TO: All Staff  
FROM: Public Works Plan Review Team  
DATE: November 1, 2022  
SUBJECT: SX-22-00018 Lauckhart

The Public Works Department has reviewed the Request for Shoreline Exemption.

SITE PLAN

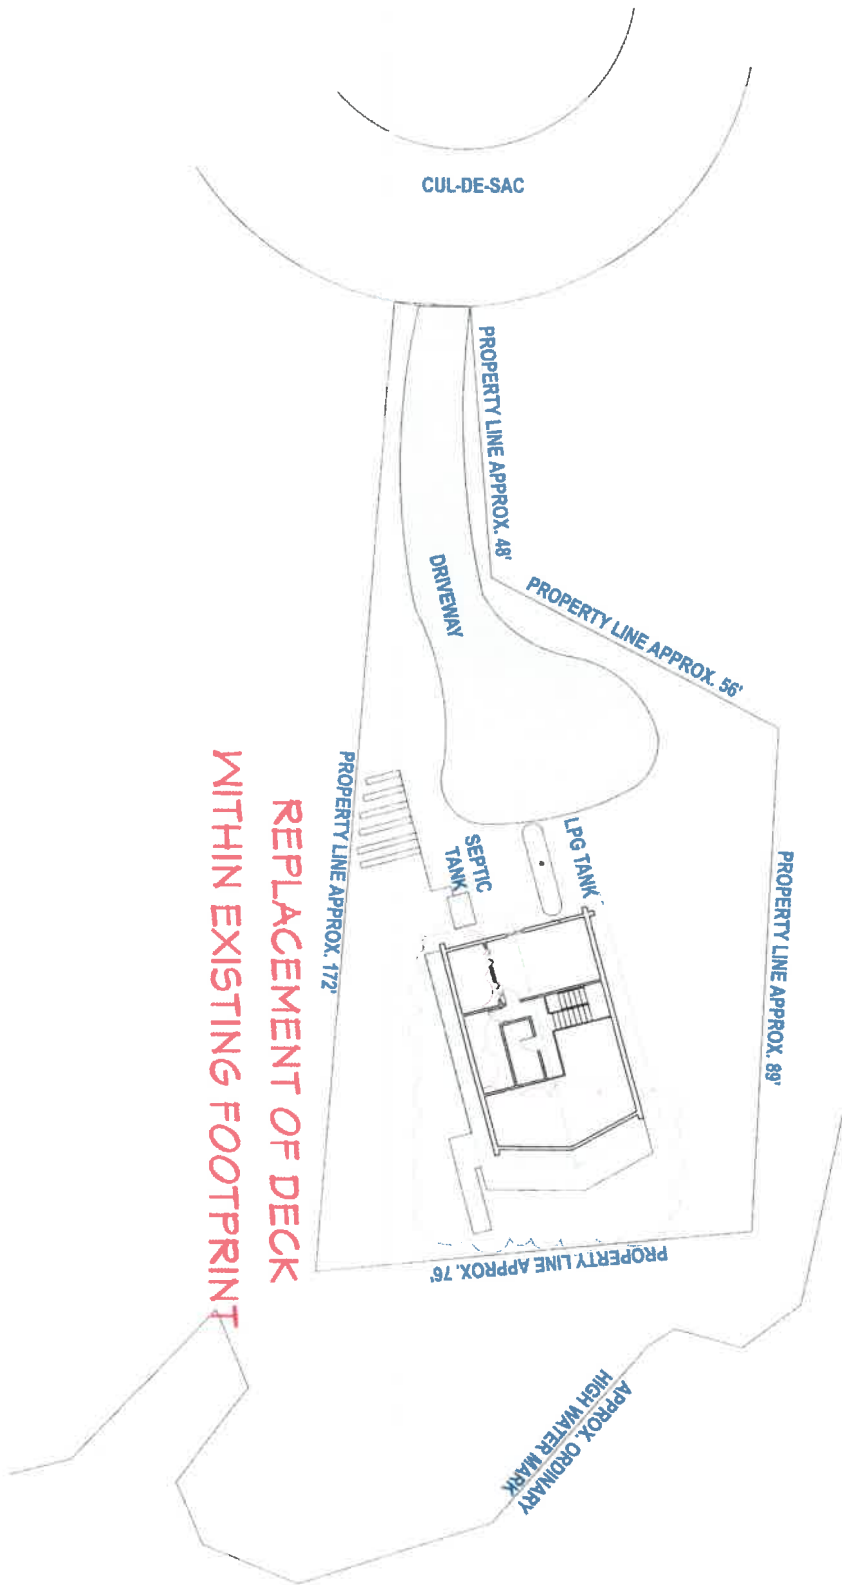
The proposed project is within the FEMA-identified special flood hazard area. Unless FEMA issues a letter of map amendment removing the structure from the special flood hazard area, a floodplain development permit is required, and the project will need to meet the standards identified in KCC 14.08..
